Application No: FG/58/14/PL

### Recommendation Report for Planning Permission

**LOCATION:** Hangleton Farm Equestrian Centre  
Hangleton Lane  
Ferring

**PROPOSAL:** Demolition of existing barn and erection of new storage barn.

1:100 MARCH 2014 8059/2C

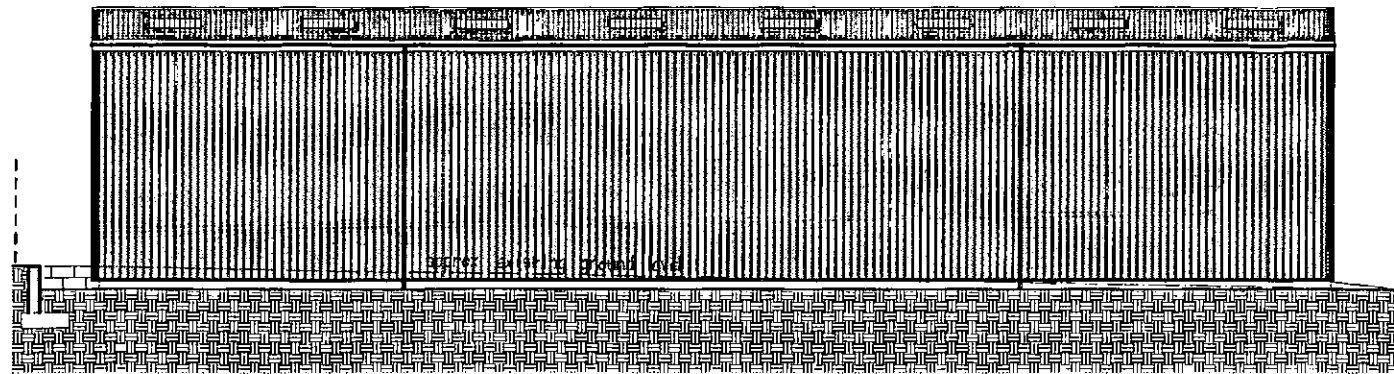
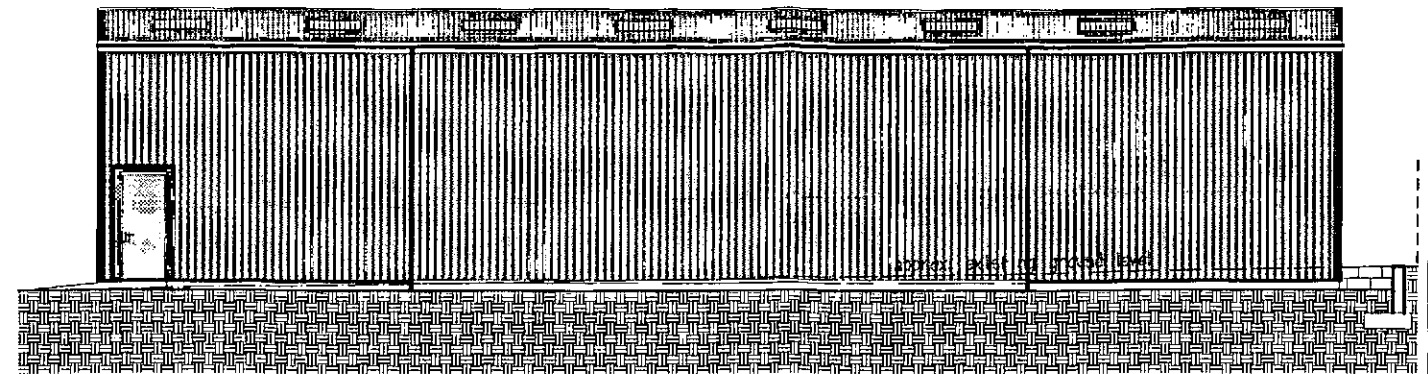
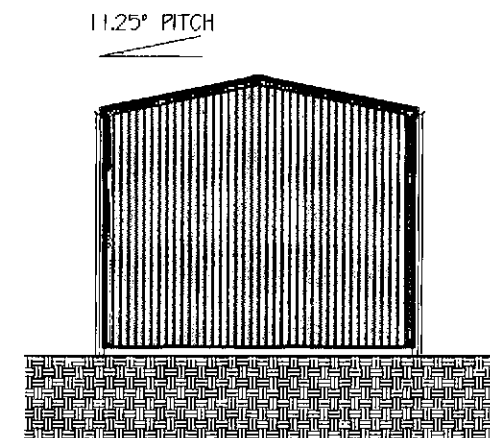
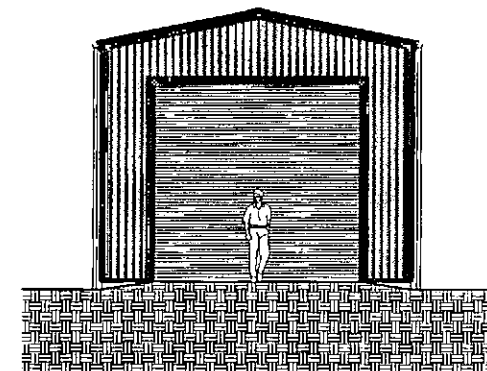
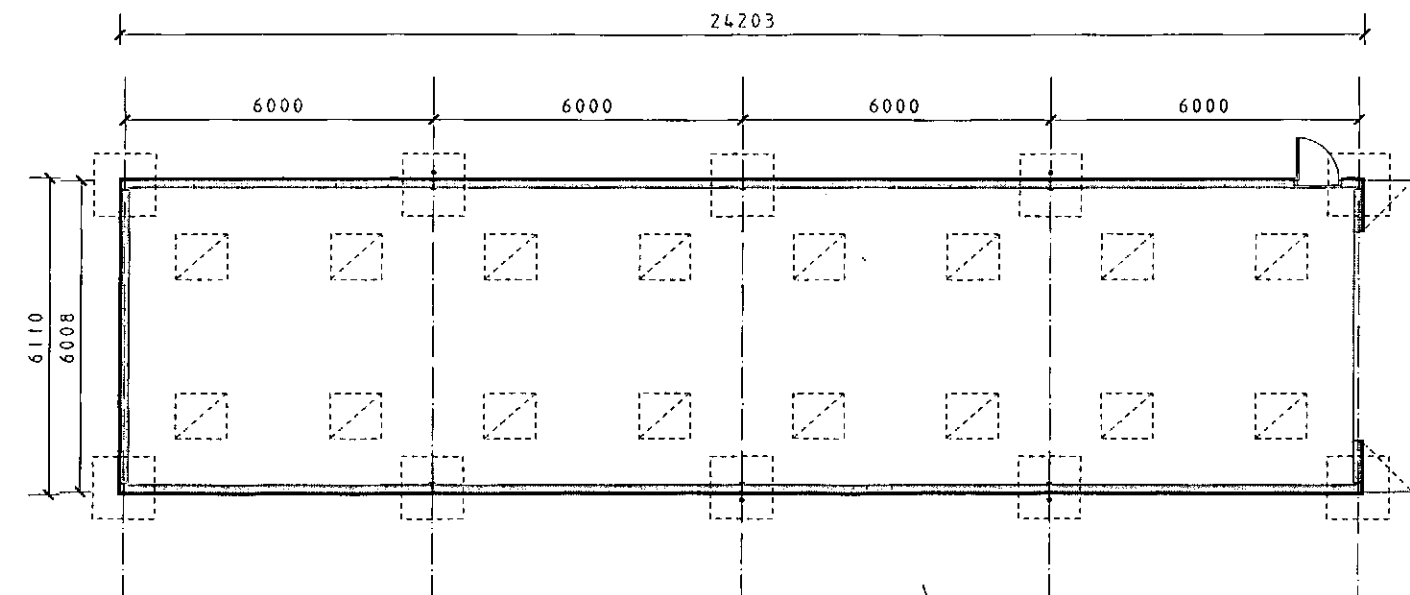
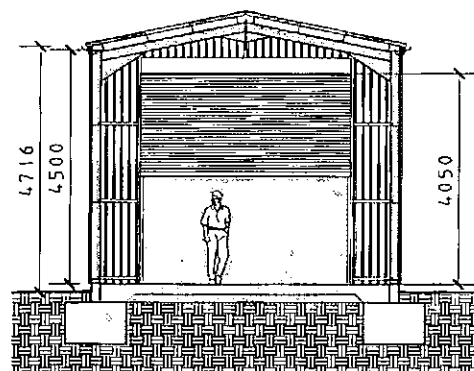
Reason for Update/Changes: The agent has reduced the height of the building by 0.5m and substitute plans have been submitted in this regard.

Objection - The proposed size of the barn is enormous.

The proposed barn will be overbearing and out of keeping with the area and it will also be clearly visible from the National Park.

The height of the barn has been reduced by 1.3m. It would not be readily visible from outside the site given the presence of tree screening to the west and other structures within the equestrian complex. The colour and design of the building would be appropriate for this setting and the agent has confirmed that the primary purpose of the new barn is for the storage of hay and straw due to the inadequate amount of existing suitable storage space. It is essential to have a barn of the submitted size to store hay and straw and benefit from the economies of scale derived from large orders.

- 2 The development hereby approved shall be carried out in accordance with the following approved plans 8059/1A and 2C.  
Reason: For the avoidance of doubt and in the interests of amenity and the environment in accordance with policy GEN7 of the Arun District Local Plan.
